## Portishead Branch Line (MetroWest Phase 1)

**TR040011**

**9.34 ExA.CWR.D5.V1 – Applicant's responses to Written Representations submitted for Deadline 4**

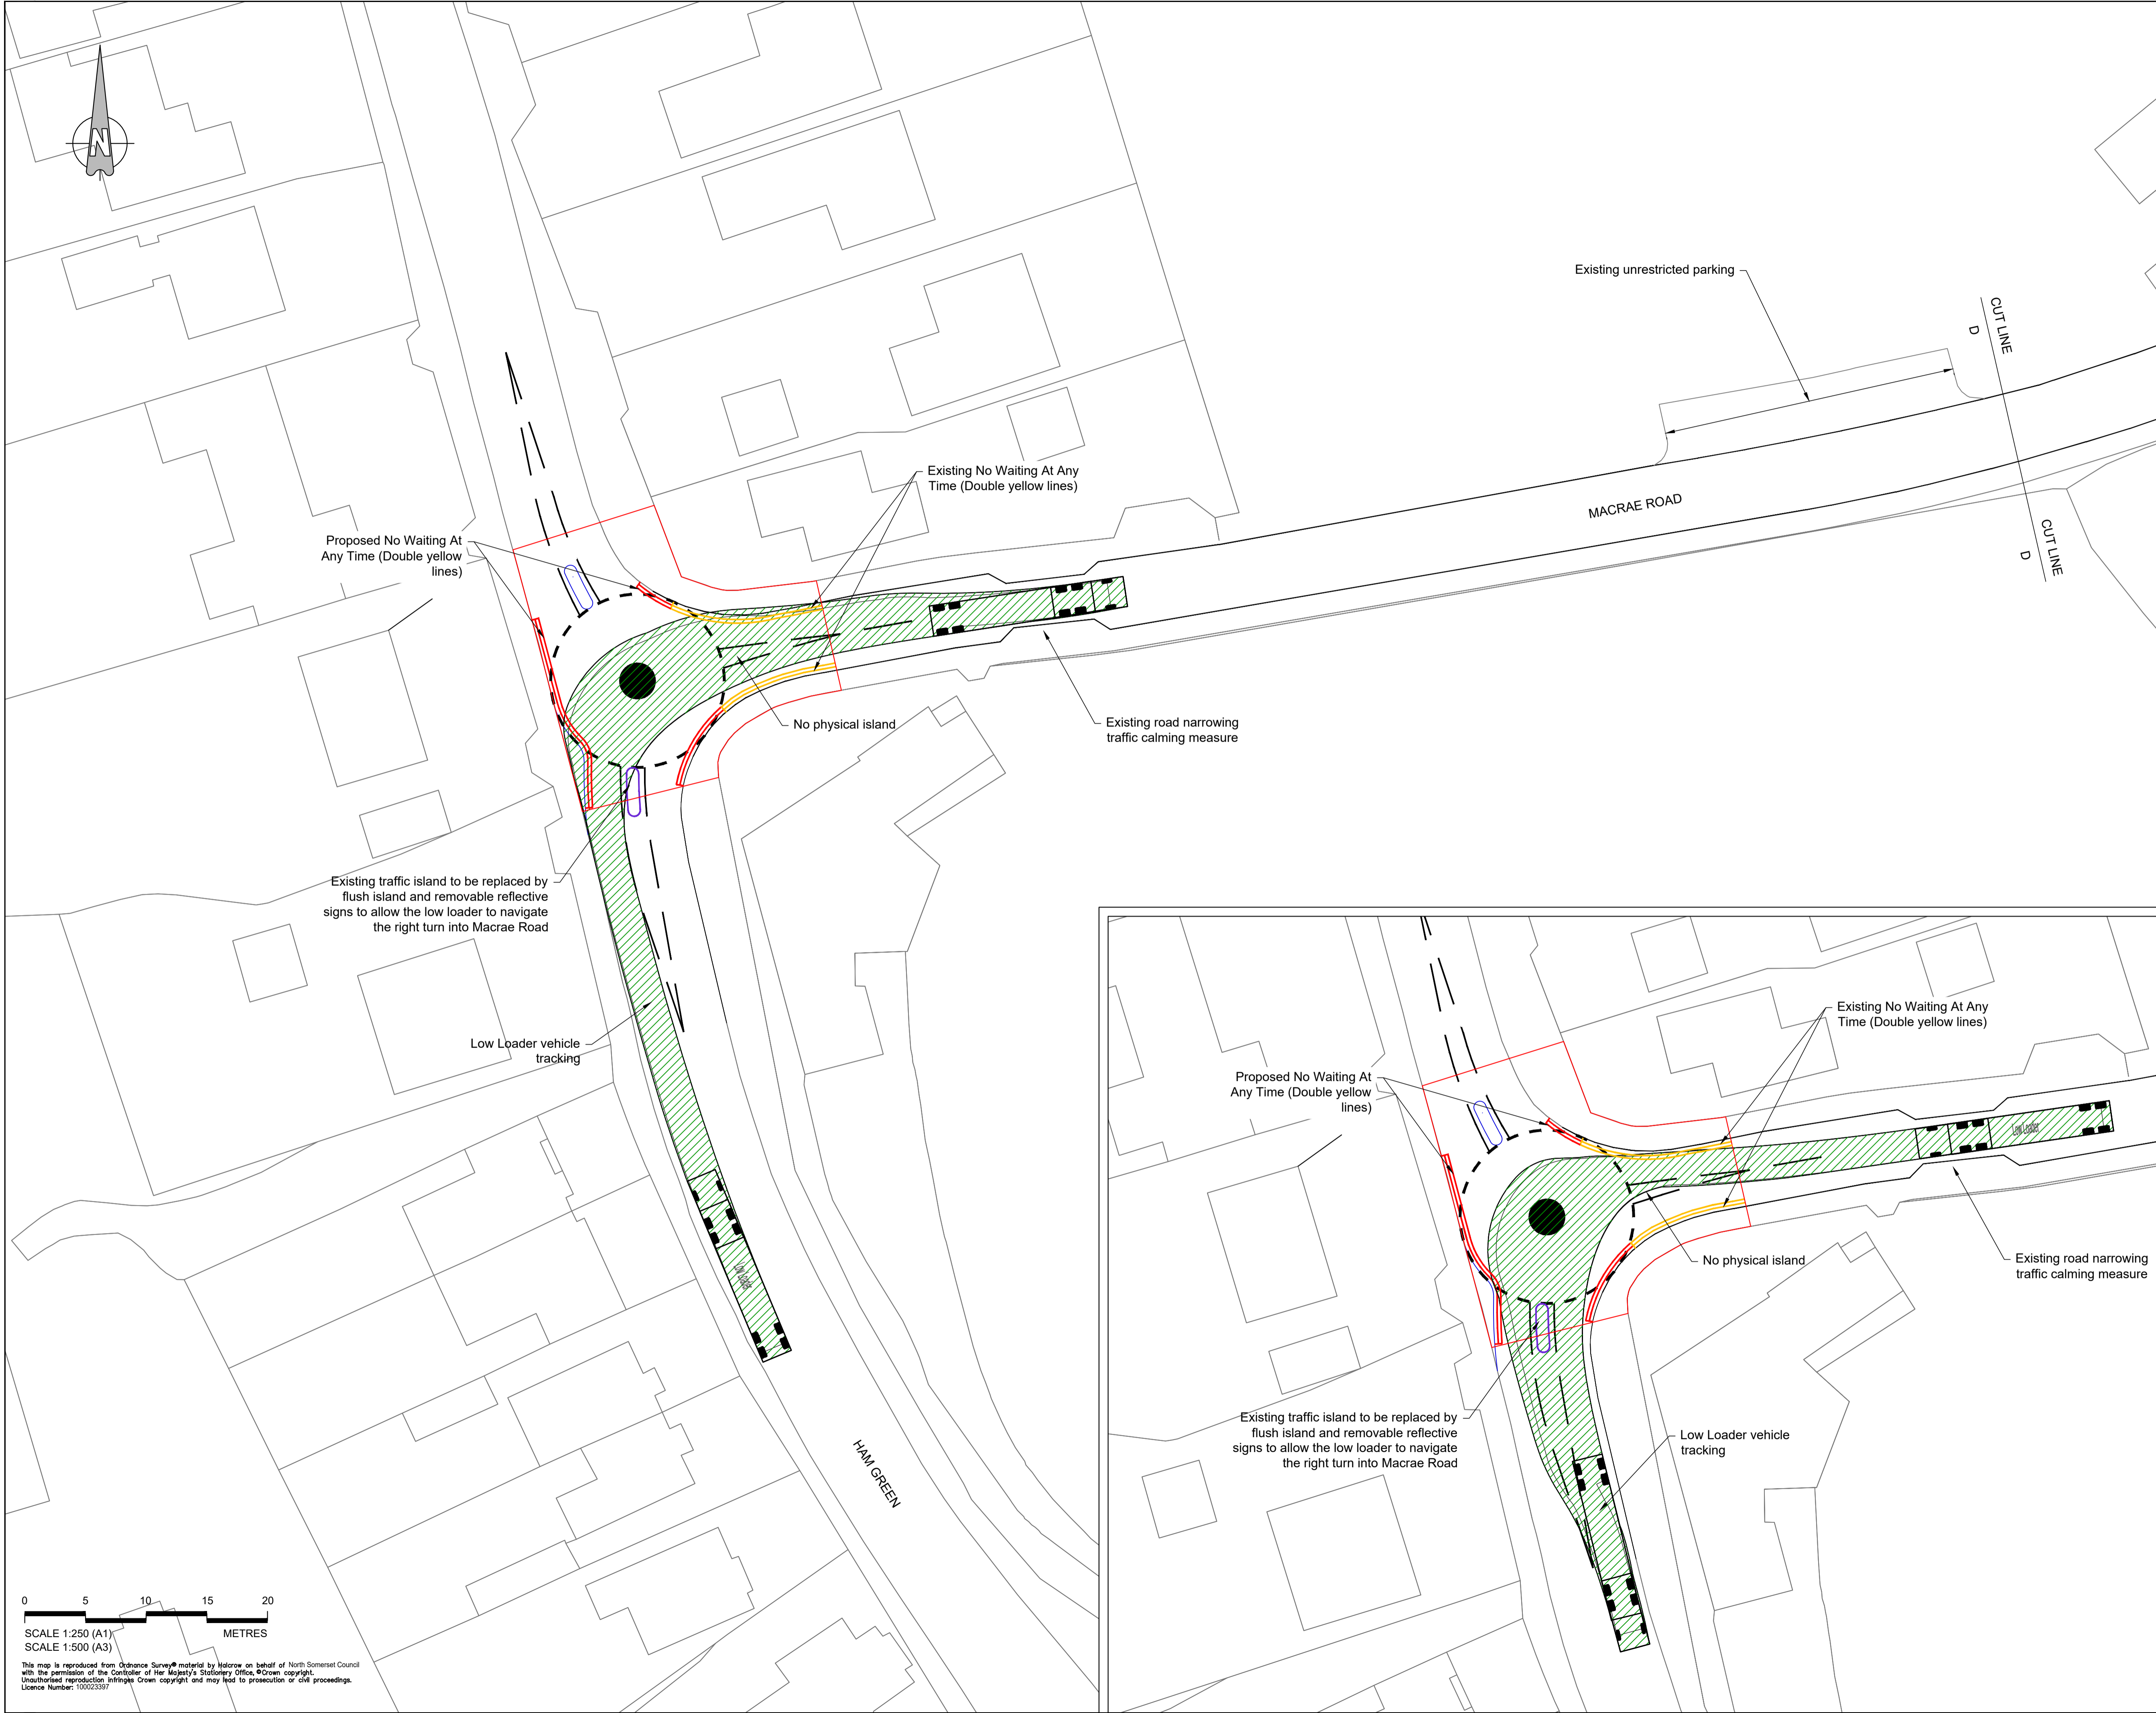
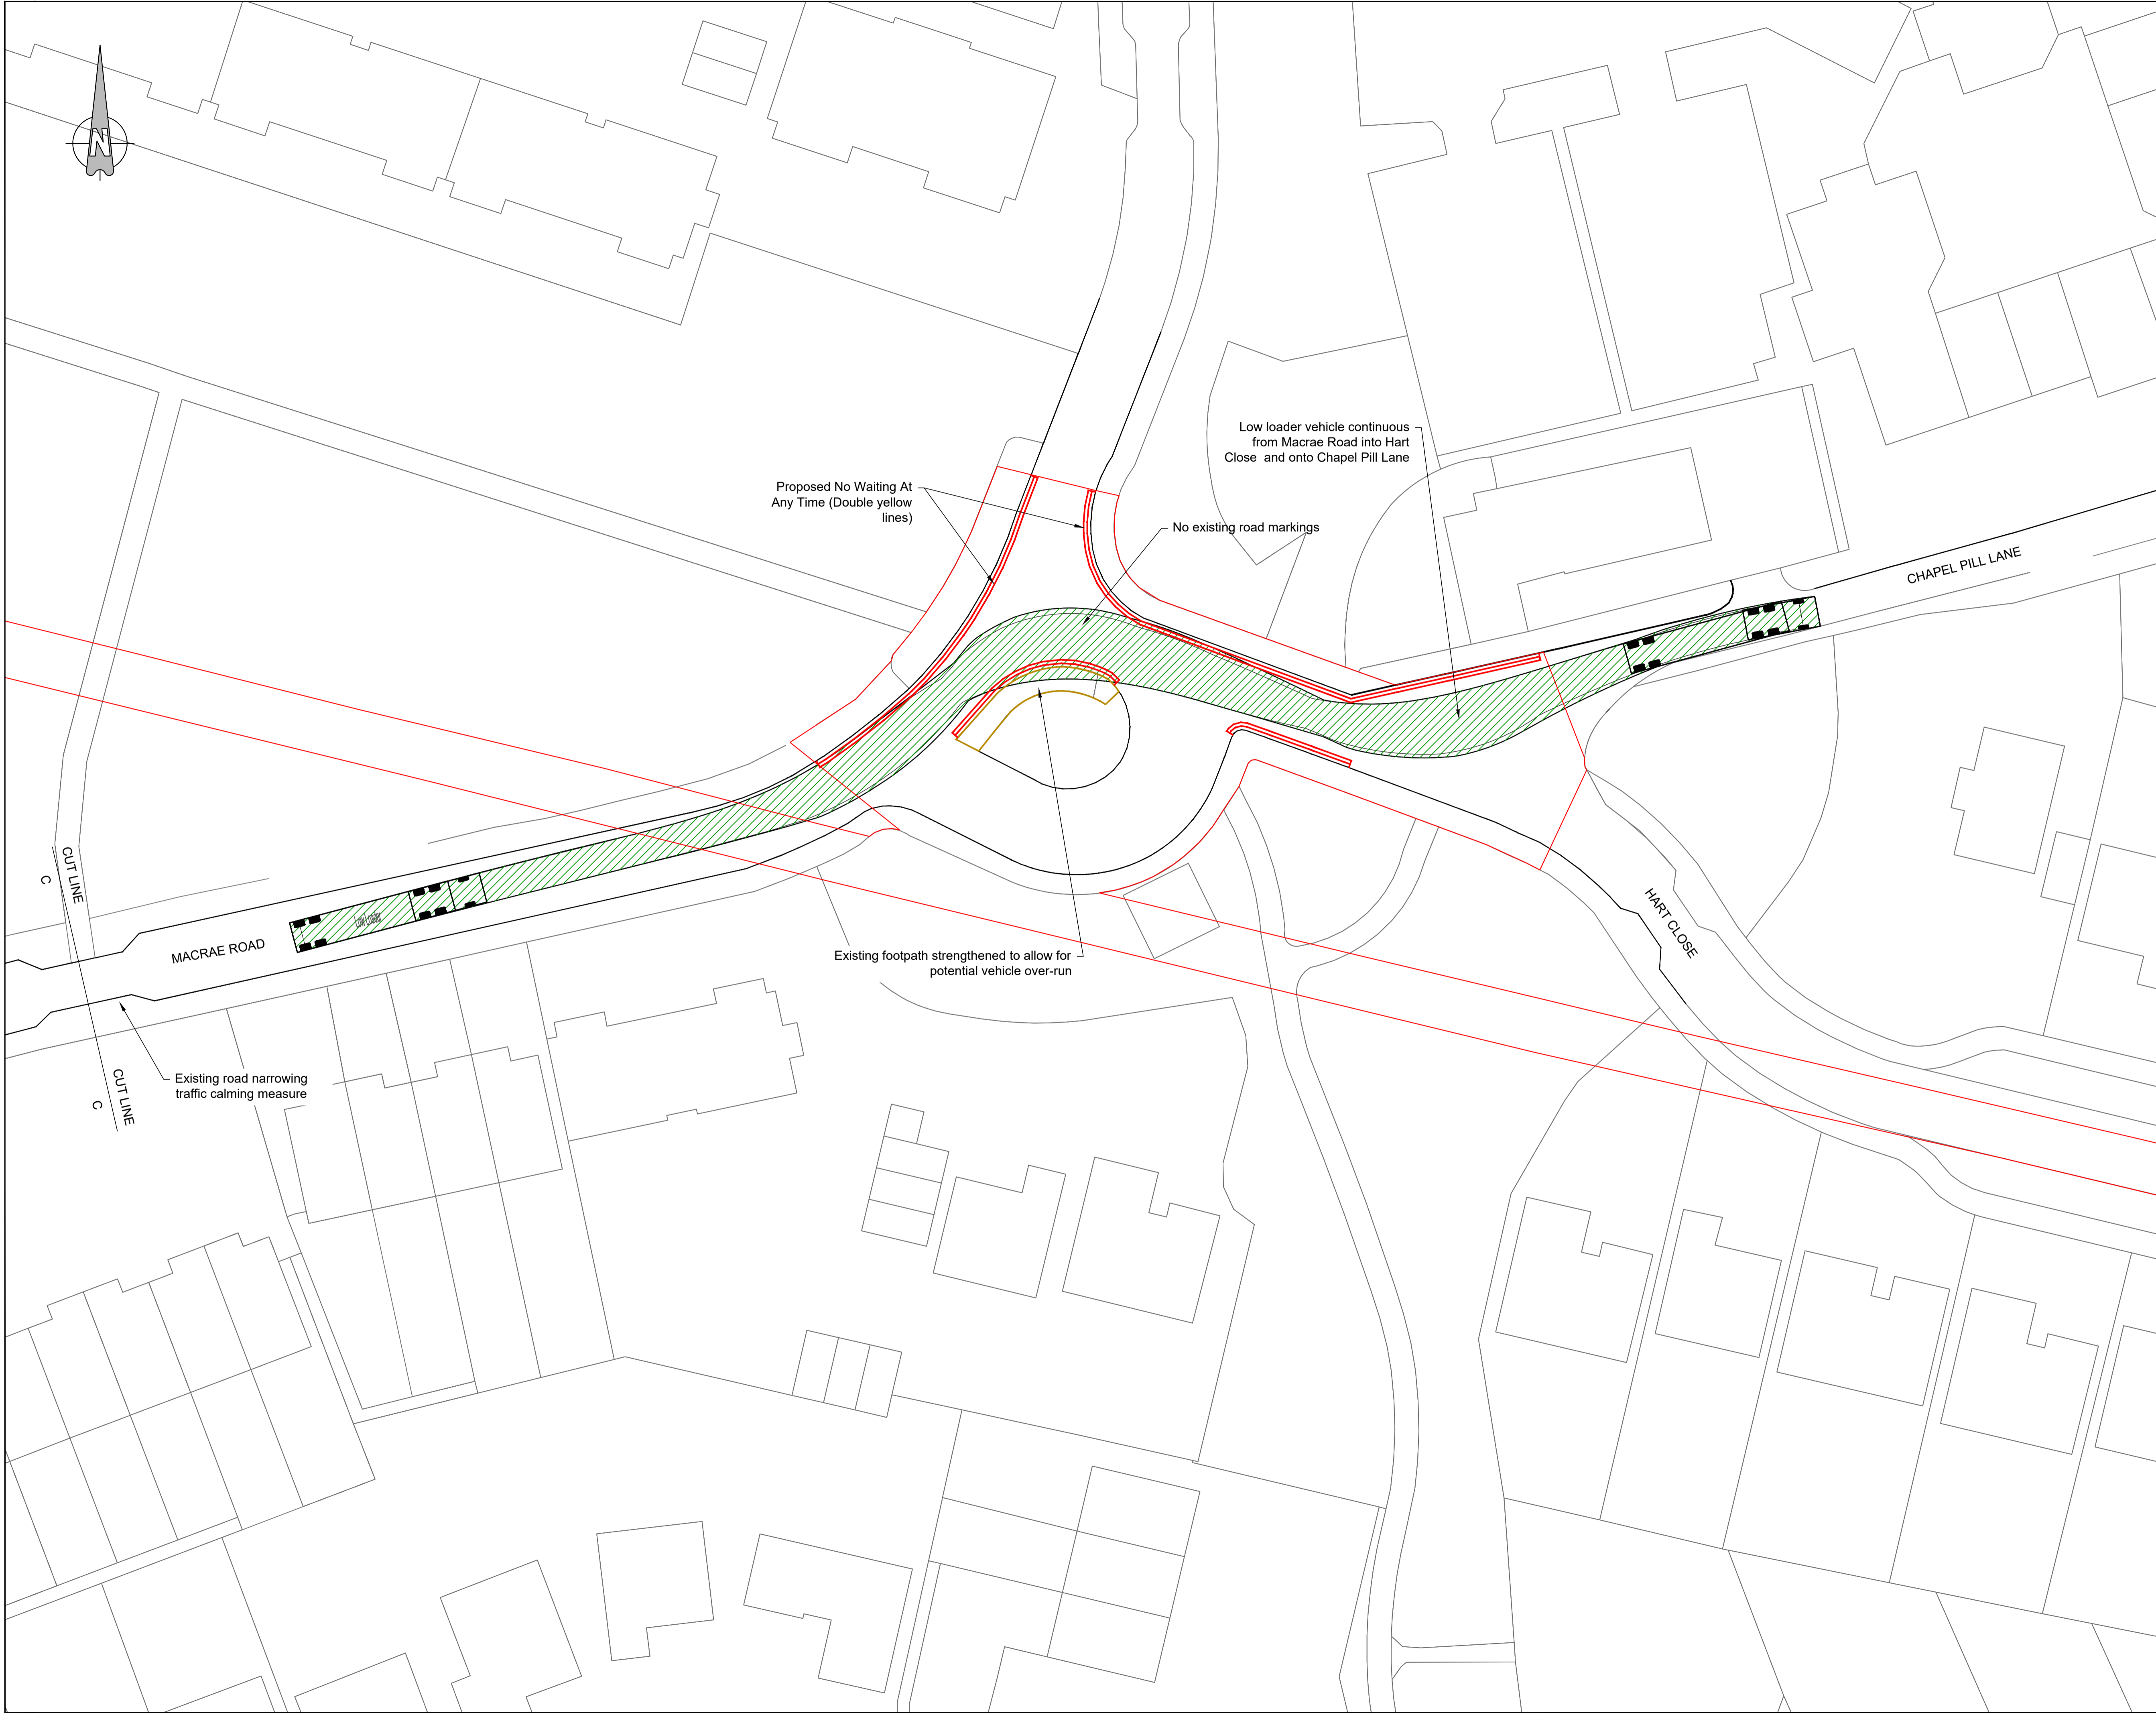
001096-D4-002		<p>4.2 Secondly, in response to the applicant's apparent concerns replying to questions raised at the Open Floor Hearing of 19th October, that vehicles accessing the Pill Tunnel compound via Hayes Mayes Lane would breach a restrictive covenant and cause damage to hedgerows and trees, it is worth noting that rail maintenance teams equipped with chainsaws have previously cleared the lane by cutting the hedgerows on both sides to lay piping through the hedgerow during Pill Tunnel drainage operations that were previously carried out using pumps and service vehicles parked in Hart Close. A drainage operation that resulted in parts of the Hayes Mayes Lane hedgerow being removed and replaced with barbed wire to prevent pedestrian access from and to residential development. Photographs that evidence the extent and continued hedgerow/tree cutting in Hayes Mayes Lane can be provided if needed.</p>	<p>The use of Hays Mays Lane and the minor vegetation works by Network Rail was not authorised by the Council as freehold owner (albeit the Council has no objection to such occasional use). In any event the use of the access by Network Rail to the former Ham Green Halt is likely to be an overriding interest burdening the freehold of Hays Mays Lane and one the Council took the land subject to when it became the freehold Owner. The occasional use by Network Rail of Hays Mays Lane for access does not in any event breach the restrictive covenant imposed by Redrow Homes.</p>

001096-D4-004		6. It therefore appears that the applicant has chosen, for reasons that have not been satisfactorily explained, to access the Pill Tunnel compound via Chapel Pill Lane, resulting in more environmental damage than is justified, when an alternative means of access to obviate or mitigate these risks is available via Hayes Mayes Lane – a solution that would address lake access Rights of Way issues that are also matters of concern. An extract of a note received from concerned residents, which highlights the increased highways safety risks to cyclists, walkers, joggers and families with young children (some pushing buggies and pushchairs), of the dangers of mixing HGV and other vehicle movements with high volume recreational use on this section of the Avon Cycleway is attached at Appendix 2. In any event, to avoid further compounding highways safety risks at this sensitive location, shared MetroWest access to a proposed housing development referenced in the Pill and District Neighbourhood Plan, on which a public consultation was opened by PDCLT and Alliance Homes on 18th January 2021 <a href="https://www.alliancehomes.org.uk/chapelpill">https://www.alliancehomes.org.uk/chapelpill</a> , should be refused.	<b>Environmental damage:</b>  If Hays Mays Lane were used as an alternative means of access, there would be impacts on the trees and hedgerows that border the track. The eastern hedgerow and trees are described in the Extended Phase 1 Habitat Survey paragraph 4.4.15 (APP-133; DCO document reference 6.25) as 'A strip of woodland borders the track into the proposed compound area, comprising mature sycamore <i>Acer pseudoplatanus</i> , elm <i>Ulmus</i> sp., hawthorn, blackthorn and young ash'. There would be adverse ecological effects from removing the eastern hedgerow and trees to allow for the use of the track. The chosen route into the compound avoids the impact on the hedgerow with trees. Avoidance is one of the key principles which underpins Ecological Impact Assessments to 'Seek options that avoid harm to ecological features (for example, by locating on an alternative site)' (CIEEM guidelines for Ecological Impact Assessment, 2018). As detailed in the ES Chapter 9, Ecology and Biodiversity paragraph 9.5.1 (AS-031; DCO document reference 6.12) 'Measures adopted as part of the scheme include careful design of the project to ensure key receptors are avoided where possible. These measures are not necessarily required to mitigate likely significant effects but have been identified as those that can avoid or reduce effects on ecology and biodiversity and have been incorporated within the design of the DCO Scheme'.

Ref no.	Party	Response	Applicant's response
			<p>To avoid impacts on the western hedgerow and trees alongside the track by root compaction by vehicles and damage to limbs etc, the track would need to be moved to the east to be outside of the root protection area and will therefore be within the field identified in the DCO Scheme for the compound area.</p> <p>Hays Mays Lane is included in Ham Green Tree Preservation Order, and trees covered by the Order would need to be removed as noted above.</p> <p><b>Access to fishing lakes:</b> The Applicant has negotiated with the holder of the fishing lake access rights an alternative route for the access to the lake so that this will be available during construction and after construction.</p> <p><b>HGV / TRAFFIC ISSUES:</b> The updated traffic data in the CEMP indicates that the compound will have very low usage. During construction there is estimated to be one HGV accessing the site each day on average.</p> <p>Post-construction, Network Rail have confirmed that routine site traffic attending site approximately once every week using small vehicles (such as transit vans). Material deliveries are likely to occur once every 8 to 12 weeks and will be undertaken during the night-time period to align with track possessions. It is noted that there may be more significant renewal works annually where a low loader may be required.</p>
